# **APPENDIX 3**

## **Summary of Responses to Community Submissions**

**SUMMARY OF COMMUNITY SUBMISSIONS**

4 Caroline Lane
1:200

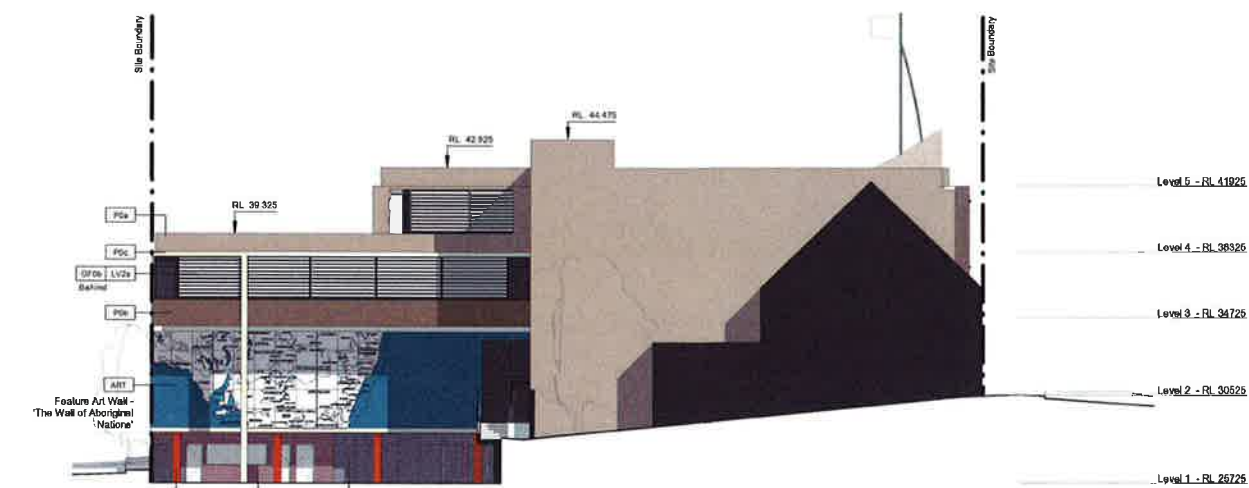
Community Submissions			
No.	From	Submissions	Response
C4	Mr A. Combe (continued)	Questions the capability of the AHC to undertake and manage the project	This is not a relevant town planning consideration of the merits of the development proposed
		The operations of the child care centre will adversely affect Caroline Street residents as a result of the noise and traffic generated by the Centre	Noise and traffic associated with the child care centre is to be satisfactorily managed. It is generally accepted town planning practice to have child care centres established in residential areas
		Traffic congestion in Caroline Street could result in motorists using Caroline Lane for ingress/egress, adversely impacting on the amenity of Caroline Street residents	The road network in this area is considered to have sufficient capacity to accommodate traffic demand and it is highly unlikely that motorists would utilise Caroline Lane principally because its location, width and proposed alignment
